**WELWYN HATFIELD COUNCIL – DEVELOPMENT CONTROL**  
**DELEGATED REPORT**

<b>APPLICATION No:</b>	<b>S6/2009/2110/FP</b>
------------------------	------------------------

This application seeks full planning permission for the erection of a single storey side extension and loft conversion to include two side dormers, roof light window to front and side and a rear hip to gable conversion.

Drawing Proposed Elevations

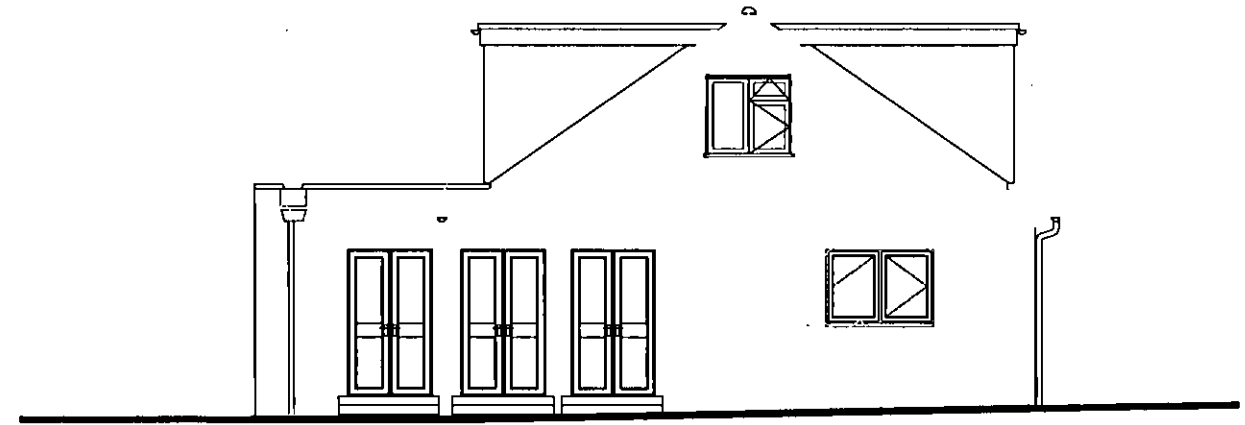
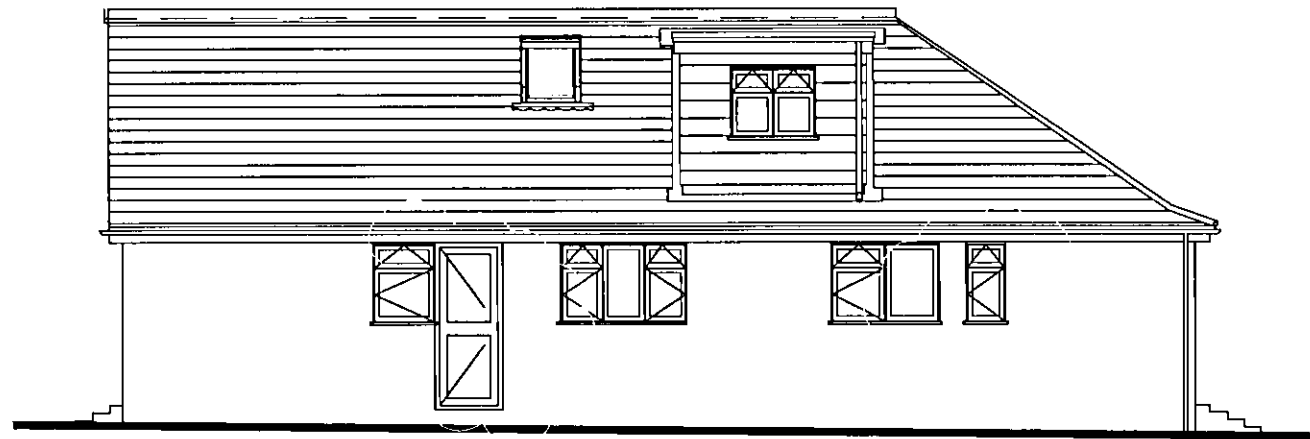
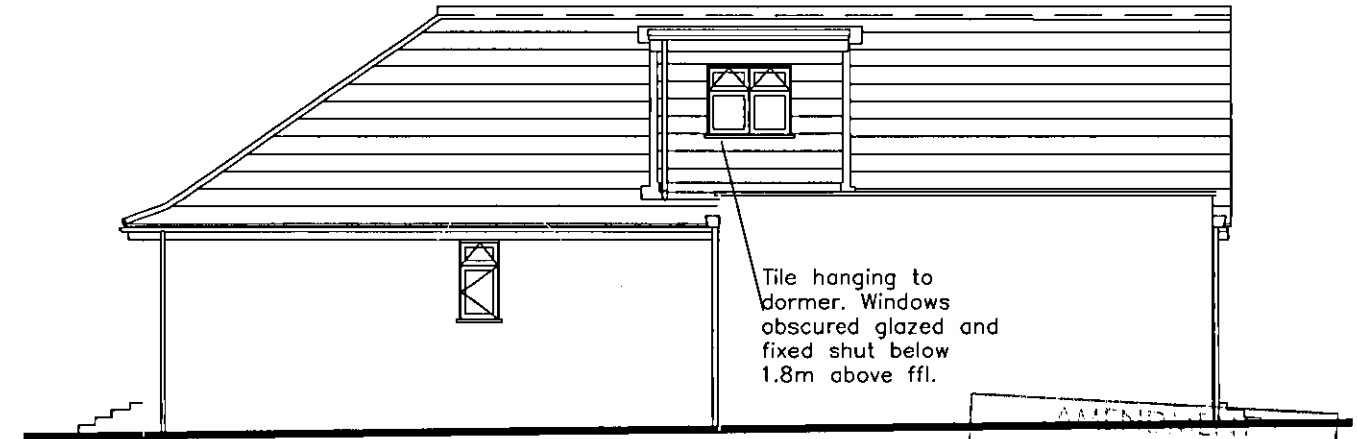
The existing ridge height and hipped roof to the front of the dwelling would be maintained. Where previously one large side dormer was proposed, the current application includes two smaller side dormers resulting in a more balanced appearance and allowing for a greater set back from the eaves and ridge. As a result the proposed dormers are considered to be subservient to the original dwelling overcoming reason 1 for refusal of planning application S6/2009/0790/FP.

The single storey side extension would be set back approximately 7.8m from the front elevation of the application dwelling significantly reducing its prominence within the streetscene and maintaining the visual separation between the application dwelling and No.34 Theobalds Road. The proposed development is considered to overcome reason 2 for refusal of planning application S6/2009/0790/FP in accordance PPS1 Delivering Sustainable Development, Policy SS1 and ENV7 of the East of England Plan 2008, Policy D1 and D2 of the Welwyn Hatfield District Plan 2005 and the accompanying Supplementary Design Guidance (Statement of Council Policy).

Project 36 Theobolds Road Cuffley
 Drawing Proposed Plans
 Format A3

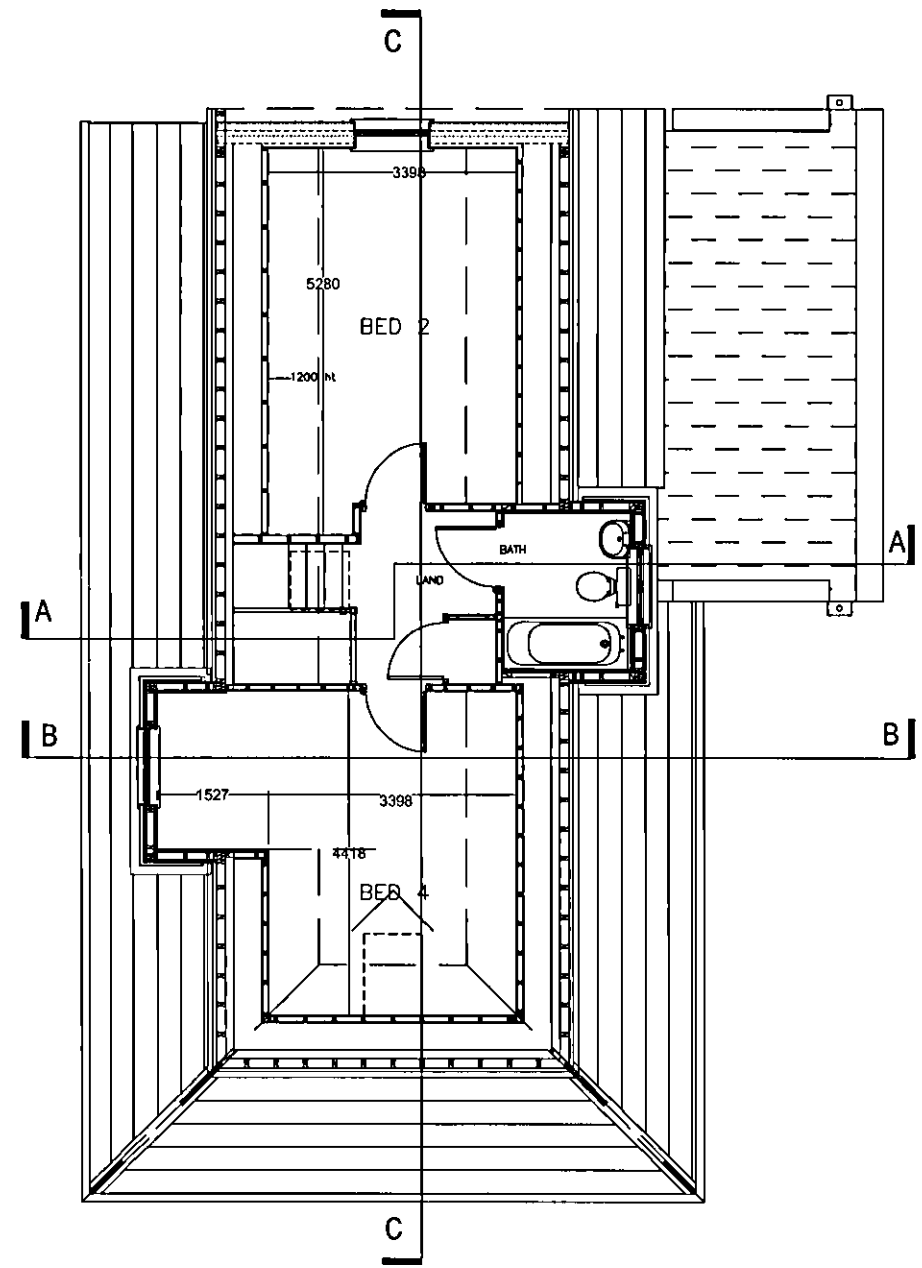
No additional windows are proposed within the north facing flank. It is proposed to relocate a number of windows within the south facing flank elevation, however this would not result in any increase in overlooking to the adjacent dwelling No.38 Theobalds Road. Two dormer windows are proposed, one each side of the application dwelling. The north facing dormer window would serve a bathroom and the south facing dormer window would serve a bedroom. It would be reasonable to attach a planning condition requiring the dormer windows to be obscure glazed and fixed below a height

of 1.8m. Accordingly, there would be no adverse impact in terms of private amenity as a result of the proposed development.

Project 36 Theobalds Road Cuffley
 Drawing Site Plan & Sections
 Format A3

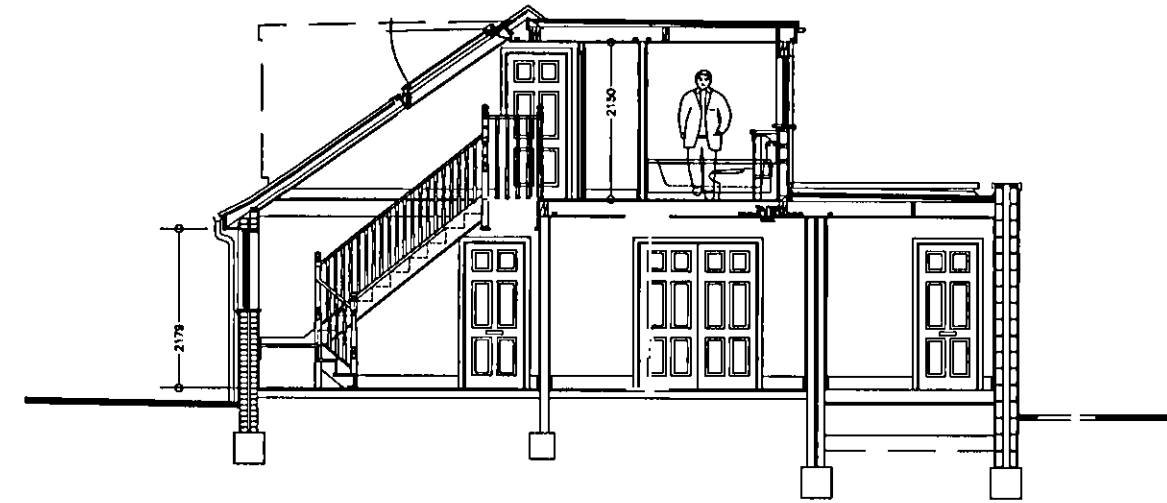
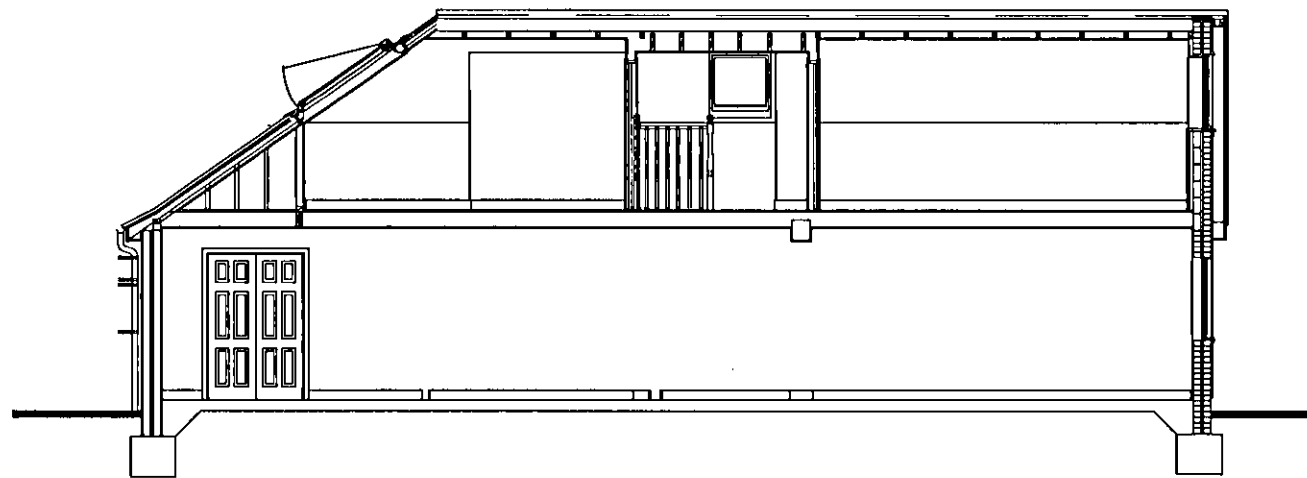
Previous planning applications S6/2009/0790/FP, S6/2007/1498/FP and S6/2007/1965/FP were refused partly due to the detrimental impact on light amenity to the windows on the south elevation of No.34 Theobalds Road as a result of the proposed side extension to the north elevation of No.36 Theobalds Road. The refused side extensions projected along the entire length of the north elevation of the application dwelling. The side extension currently proposed would be set back approximately 7.8m from the front elevation and as a result would have a reduced impact on light to the windows serving No.34 Theobalds Road. The proposed extension is unlikely to result in significant loss of light to No.34 Theobalds Road and is therefore considered to overcome the reason 3 for refusal of planning application S6/2009/0790/FP in accordance with PPS1 Delivering Sustainable Development, Policy SS1 and ENV7 of the East of England Plan 2008, Policy D1 and D2 of the Welwyn Hatfield District Plan 2005 and the accompanying Supplementary Design Guidance (Statement of Council Policy).
